RE Application AB/115/14/OUT (12- 14 Canada Road, Arundel)

I am writing to object to the planning application for 2 houses in Canada Road.

Drg Title: SITE PLAN		Drg No: 14/1950/S01
Client:	Location:	Rev: A
MR SCODFREY	12-14 CANADA ROAD	Scale: 1:200 (A3)
	ARUNDEL	Drawn by: JSW

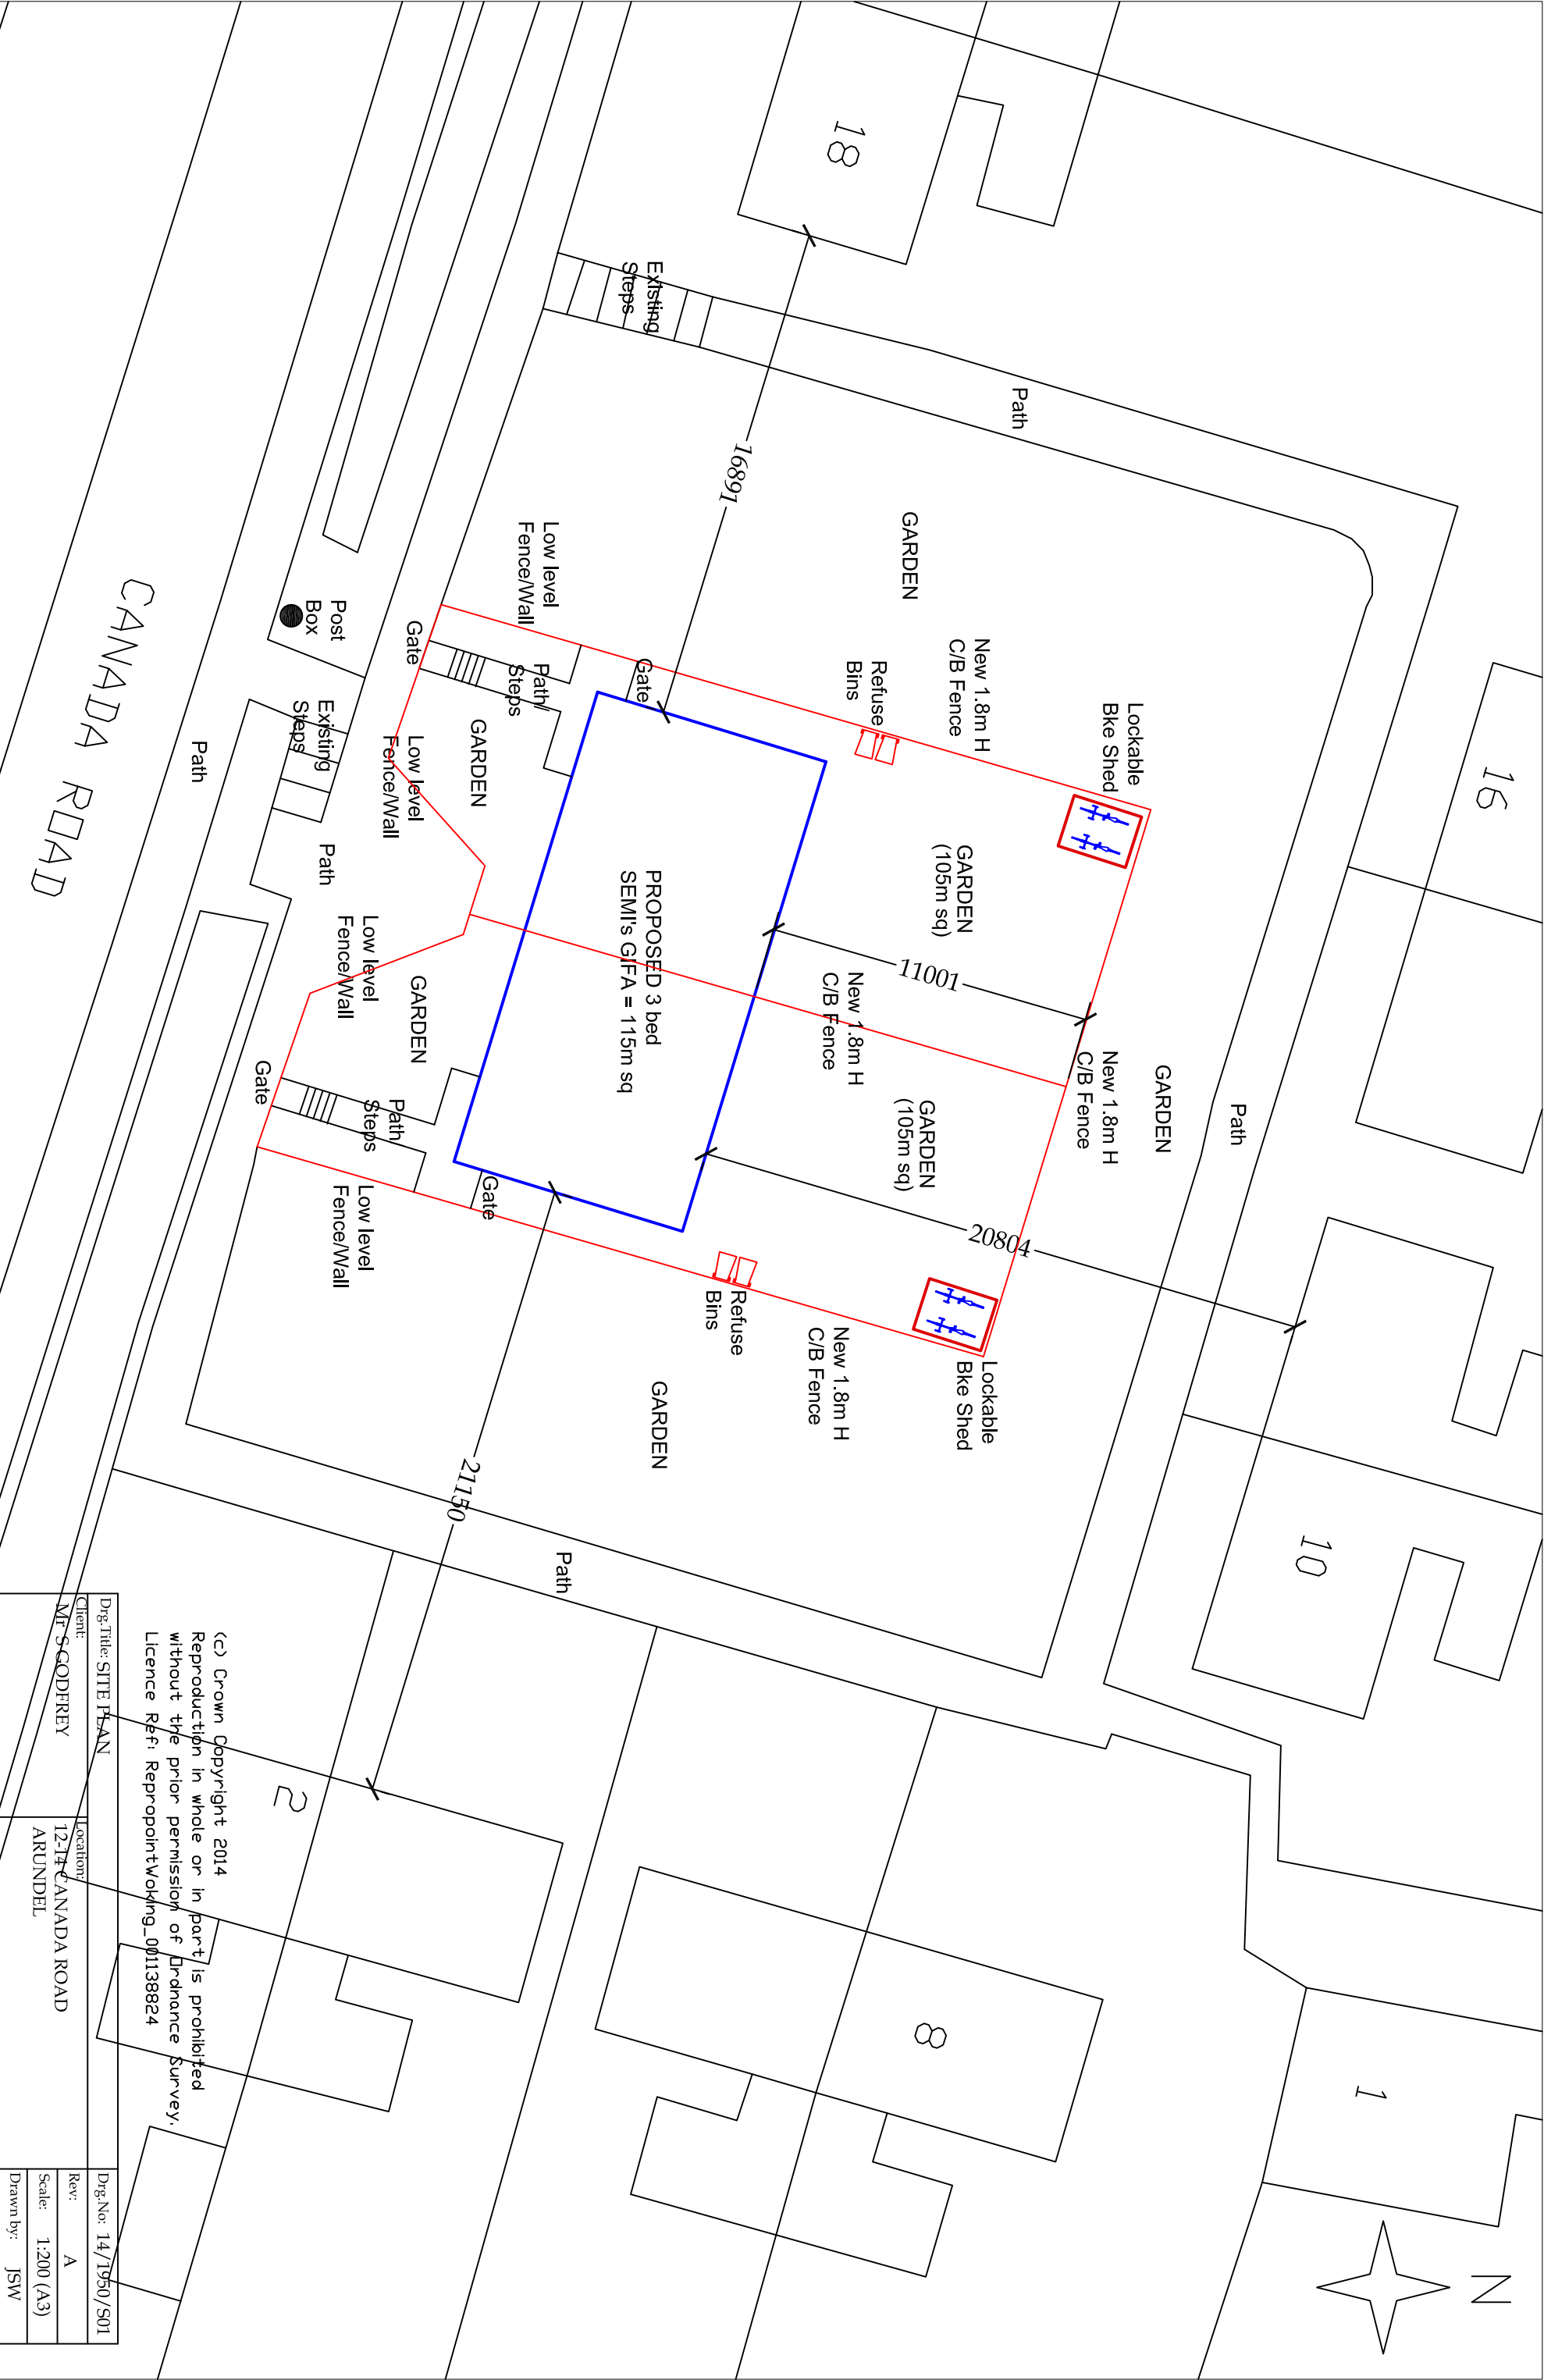
This application does not meet the requirements of the local plan 2003, in particular **Gen 7 (iv)**. The development has an unacceptable adverse impact on adjoining occupiers. The new houses will be at the same level or slightly higher than the adjacent houses and the residents of 2 and 4 will look out onto the end wall of a house rather than the natural view they currently enjoy. Although there is a slight slope to the existing front gardens, as they will be so close to one another, houses 6 to 16 and the new houses will overlook each other and the proposed rear boundaries of the new houses will be only metres away from the existing houses.

Evening and weekend car parking is difficult in this part of Canada Rd. Residents use the off road area by the park but I understand the council is fencing off this area forcing more cars onto Canada Road. I feel that the proposal should meet the parking requirements of **Gen 12**. Canada Rd is used as a rat run when the A27 is busy (now very frequently) and long rows of parked vehicle will prevent traffic from passing each other leading to possible road rage.
